14 November 2019

Our Ref: N-18047

RE: NIHON UNIVERSITY NEWCASTLE CAMPUS (SSD-9787) - RESPONSE TO INFORMATION REQUEST

10.5m Rear Loading Waste Vehicle - Enter / Exit via Church Street

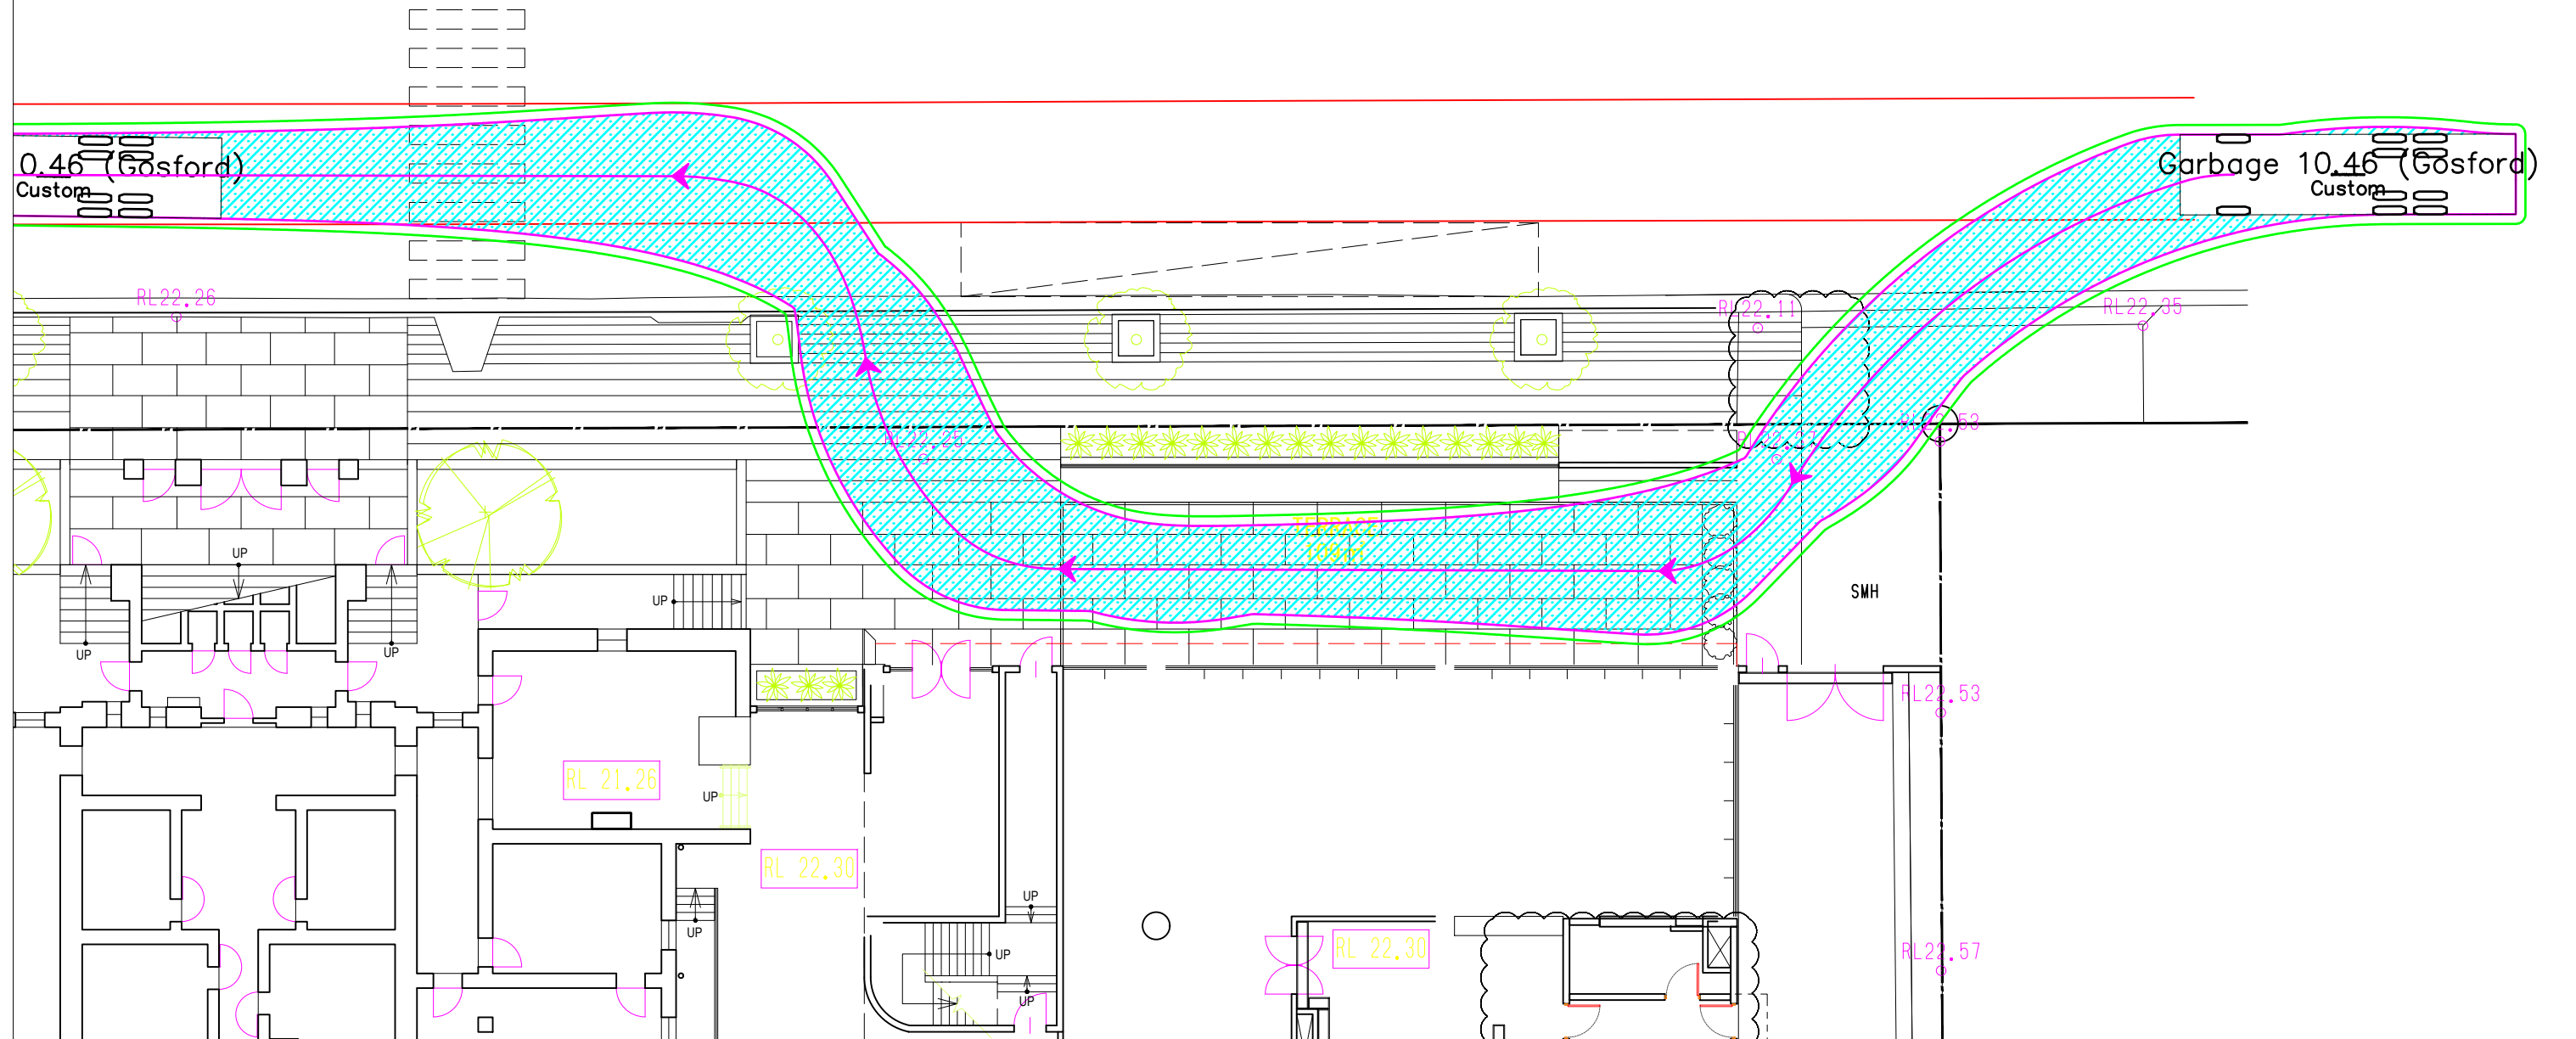
In its letter of 10 October 2019, CoN advised that the proposed kerbside loading zone in Church Street was not supported and that all service activity associated with the development would need to occur within the site. CoN recommended that the design of the development provide the following:

- A minimum 6.5m wide two-way service road*
- On-site service bay (loading dock) area complying with Australian Standard AS 2890.2*
- All service vehicles entering and existing the site in a forward direction*
- Garbage collection (servicing of bins) occurring from within the site. Garbage bins are not to be presented to the street.*

SS01 (Rev A, dated 23/10/19)	<ul style="list-style-type: none"> New drawing by SEC Solution showing the swept path for a 10.5m Rear Loading Waste Vehicle using the new Service Vehicle Deliveries Zone 	2

- Introduction of a Service Vehicle Deliveries Zone between Church Street and the Residential Building to cater for waste collection;
- Introduction of an additional driveway crossover at Church Street, adjacent to the former Courthouse building, to provide egress from the Service Vehicle Deliveries Zone; and

Garbage collection will be undertaken by a private contractor utilising a standard 10.5m rear-lift garbage truck. Collection will occur fully within the site, with no bins presented to the street. Bins will be wheeled along the internal access way, from the on-site Garbage storage rooms, and held within the site prior to the garbage truck entering the Service Vehicle Deliveries Zone. These bins will then be wheeled to the rear of the garbage truck, emptied, and returned to the Garbage storage rooms via the internal access way. This process will be managed by the on-site staff and coordinated with the private waste contractor.

As demonstrated in the swept path analysis at Attachment 2, the Service Vehicle Deliveries Zone will allow forward entry and exist for a standard 10.5m rear-lift garbage truck. Other large service vehicles (typically 6.4m small rigid trucks and 8.8m medium rigid trucks) will also use the Service Vehicle Deliveries Zone, including for food deliveries and general building servicing supplies.
